Our Ref: 15756
DPE Ref: SSDA 7317 MOD 6

SSD 7317 MODIFICATION 6 - RESPONSE TO REQUEST FOR FURTHER INFORMATION

This letter has been prepared by Ethos Urban on behalf of Mirvac Projects Pty Ltd (Mircvac) to respond to the Request for Further Information issued by the Department of Planning & Environment (the Department) on 16 May 2018 in relation to Modification 6 (MOD 6) to State Significant Development (SSD) 7317.

General Arrangement Plans 1:250
 Level 01

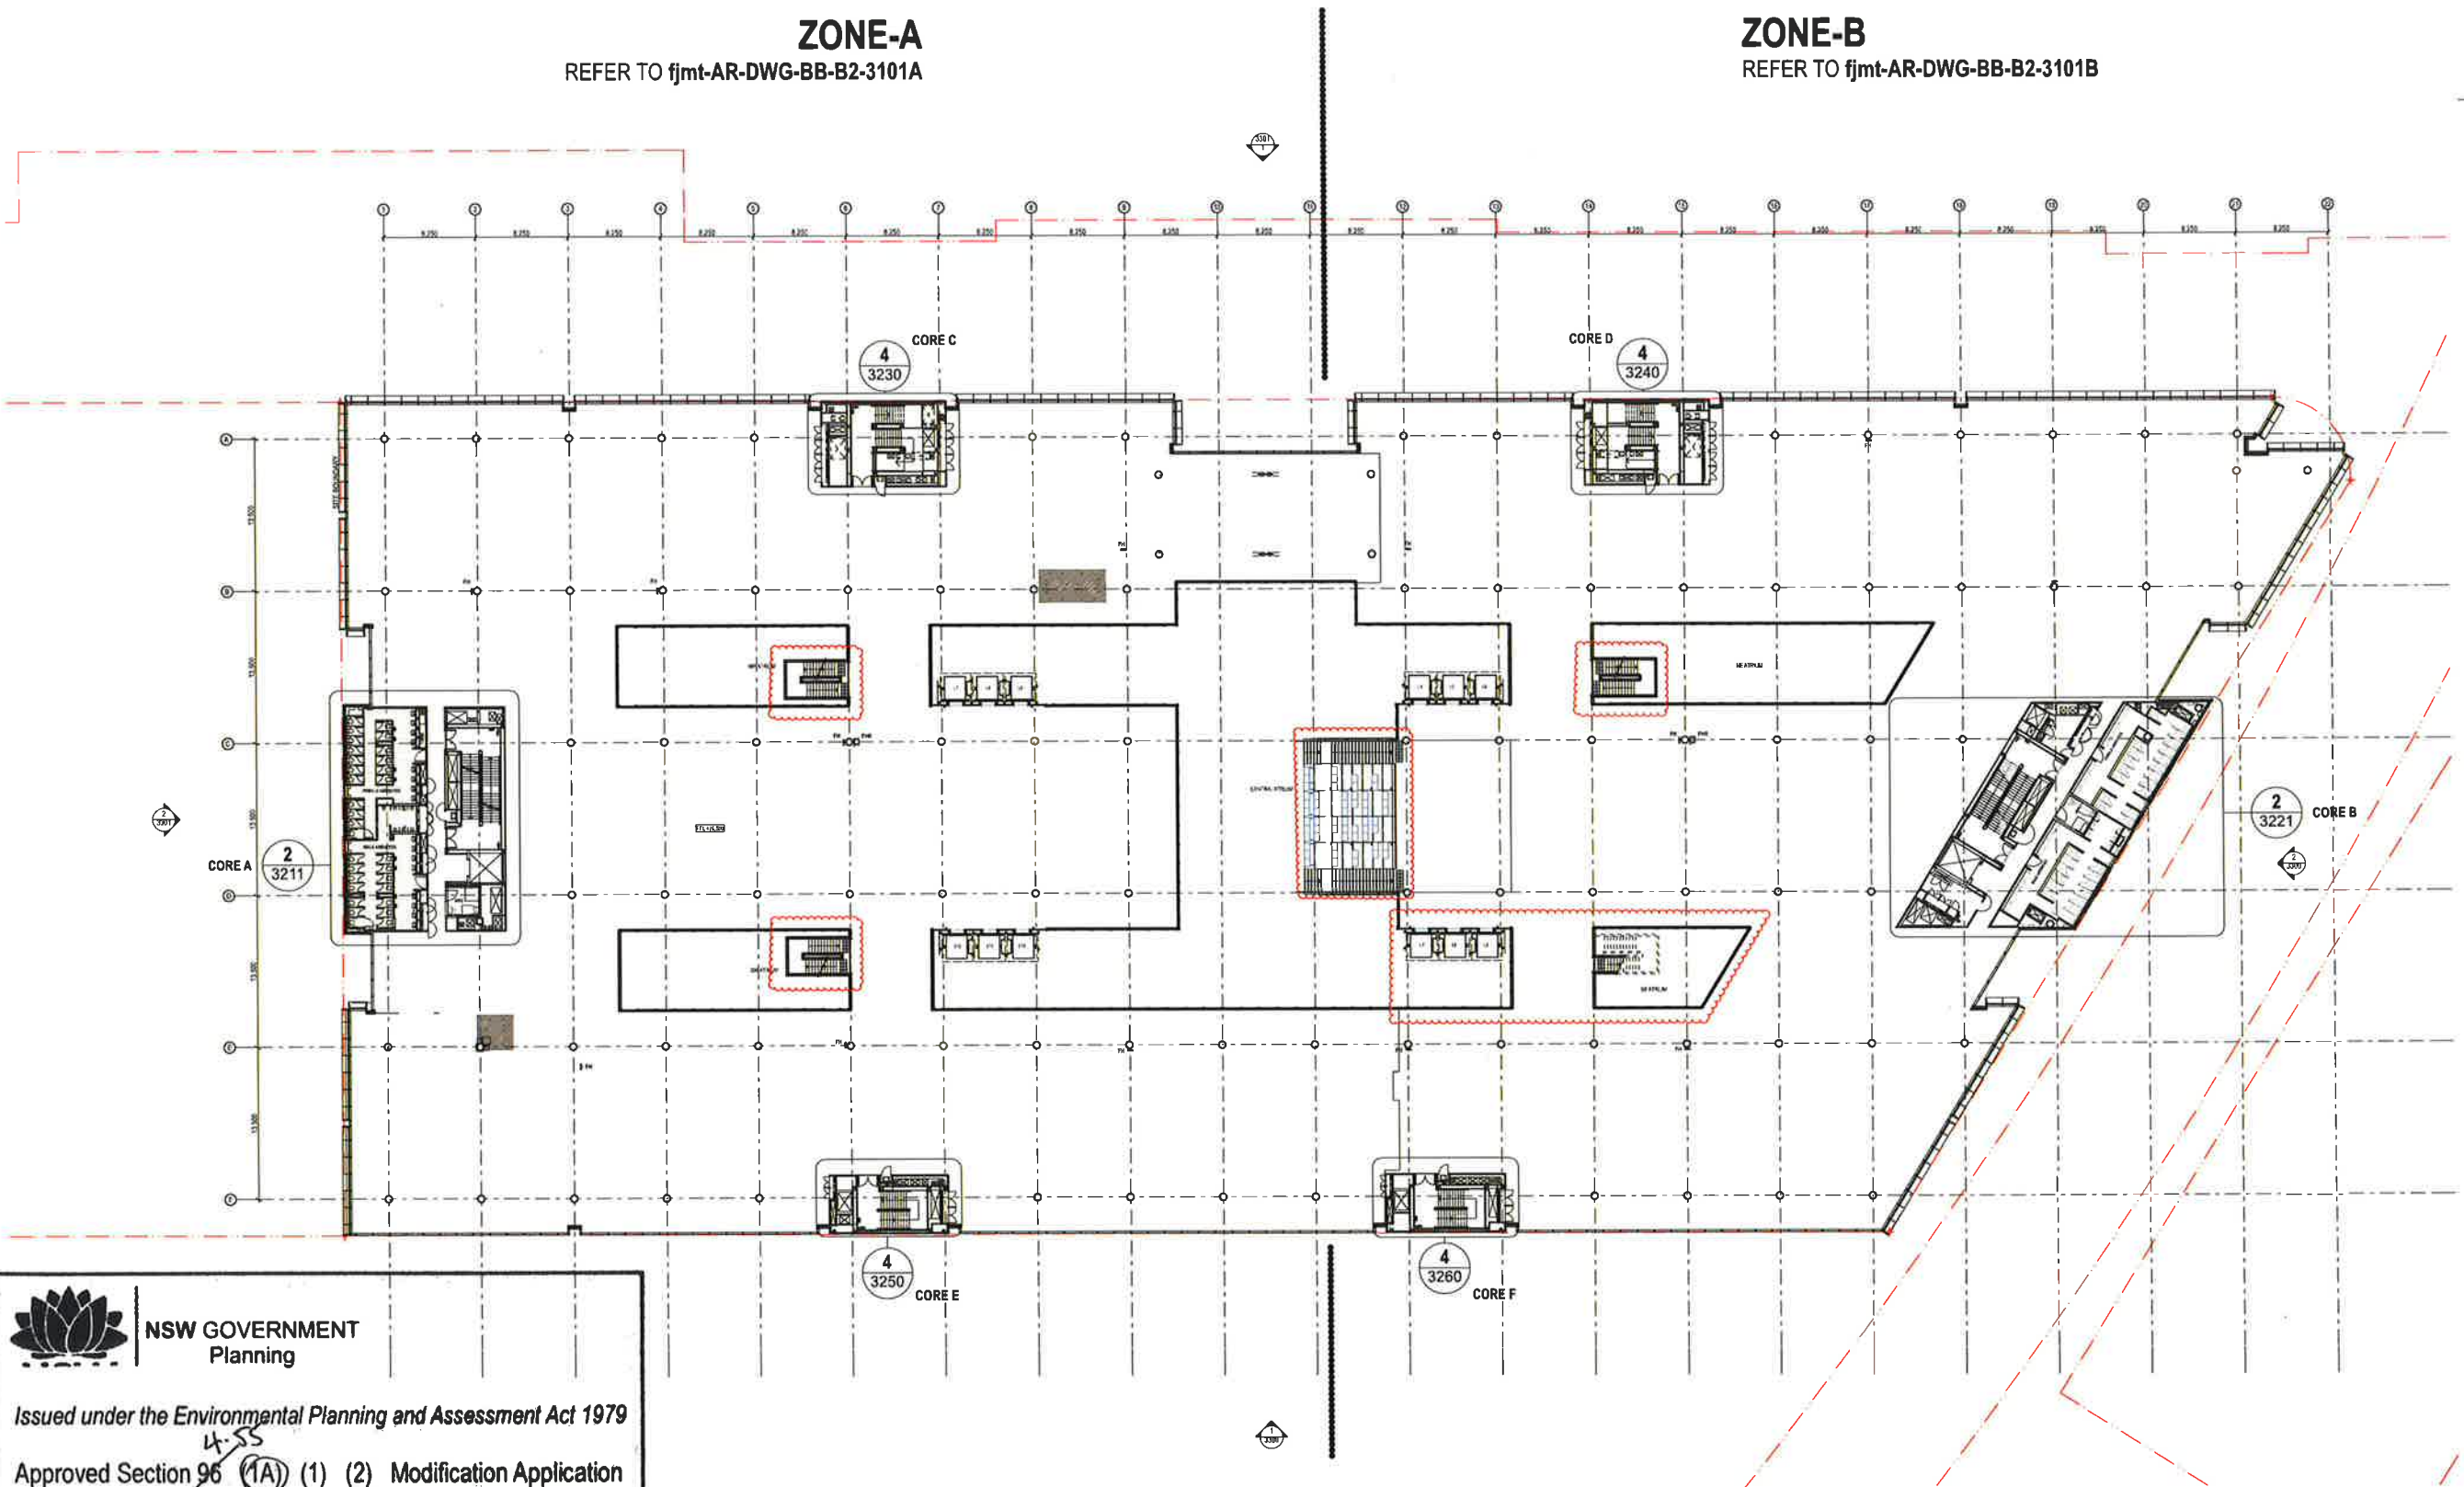
Clarify the new location of the feature stairs on the Upper Ground Floor Level, noting that these are proposed to be relocated.

Confirm whether any further floor plans require updating in response to the relocation of the south-east lift bank and internal stairs on the Upper Ground Floor Level (i.e. Level 1 Plan, Level 2 Plan, etc).

The amended location and revised design of the feature stairs is shown in the Architectural Plans at the Upper Ground Floor and Level 1 within **Attachment A**. They are also highlighted by a red box in **Figures 1 – 2**.

The revised internal atrium stairs and south-east lift bank relate to Levels 1 through to 5 and are illustrated on the amended Architectural Plans at **Attachment A**. No further floor plans are required to be updated in response to the proposed amendments.

Elevations - North & West

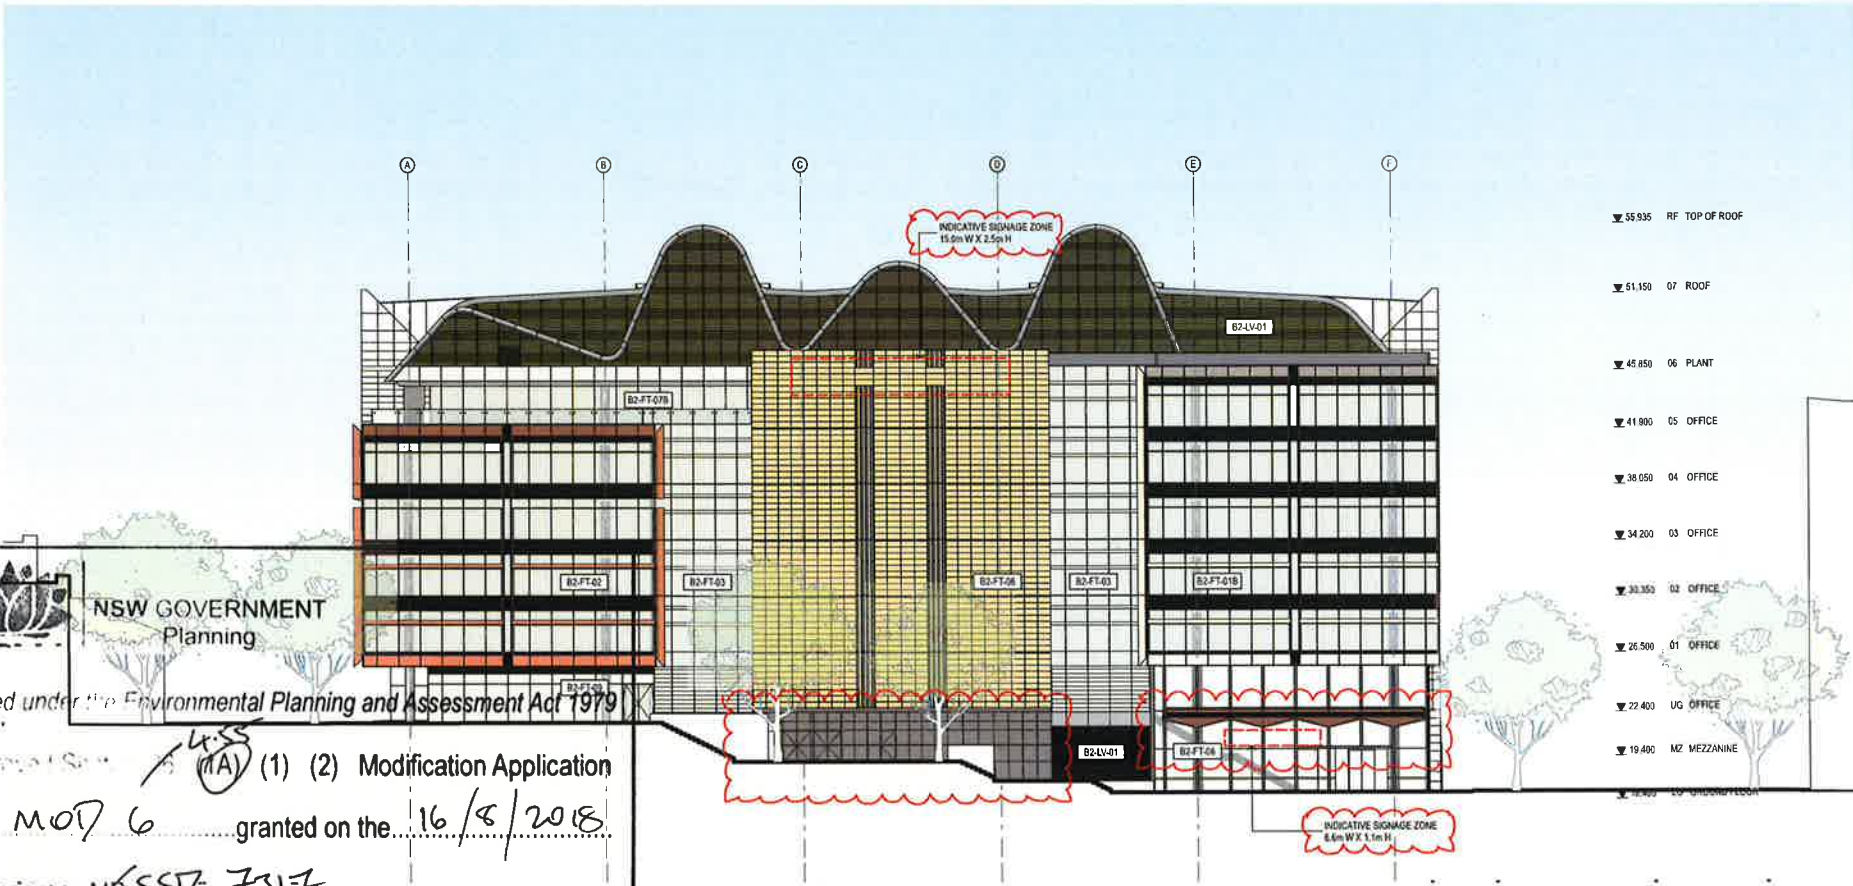
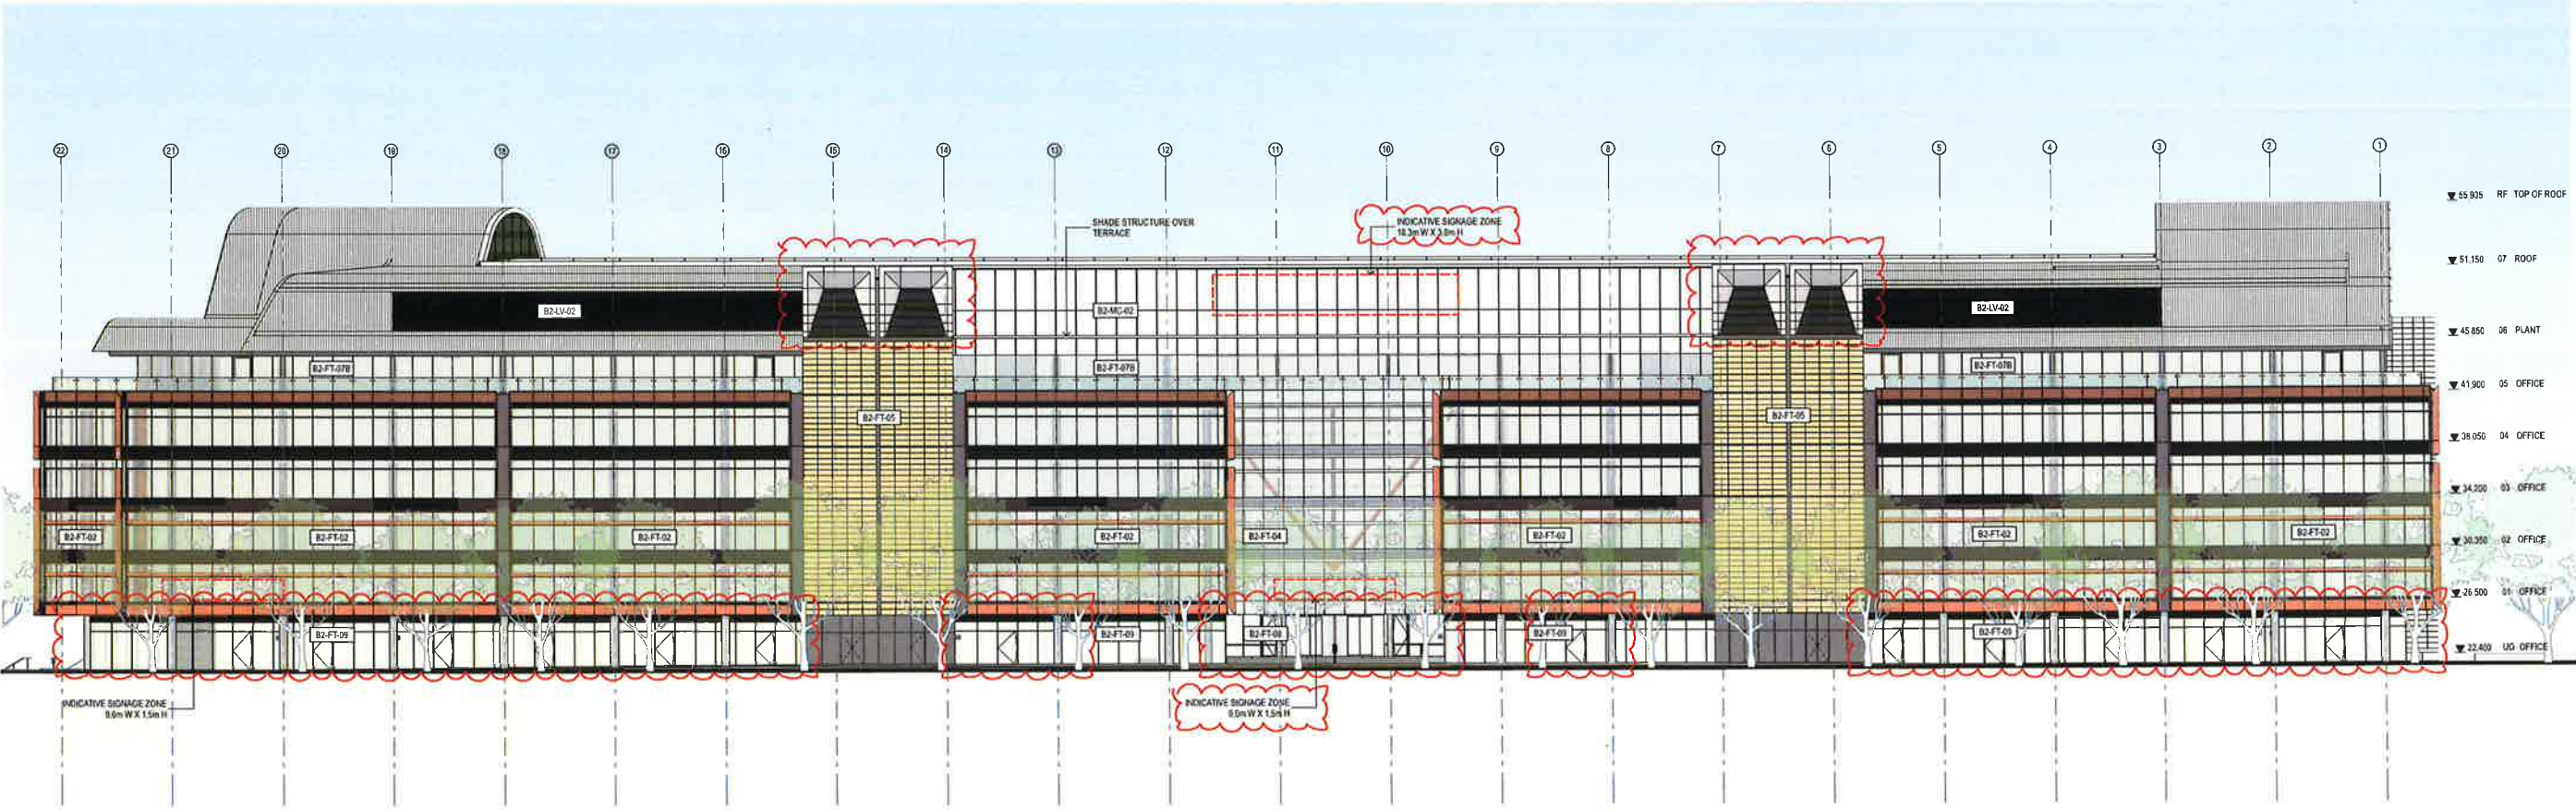
Provide an assessment of the proposed signage zone against Schedule 1 of SEPP 64 and submit any relevant details in accordance with condition F7 of the SSD 7317 consent.

The application seeks consent for the reconfiguration of two of the approved signage zones on the southern and western facades and the introduction of an additional signage zone above the entrance on the northern elevation. The detailed design of the signage proposed within each zone will be confirmed during the detailed design phase and will form part of a separation application(s). The relevant details required by Condition F7, including the final signage design, content and illumination, will be addressed in the application(s) submitted for approval prior to the installation of the signage.
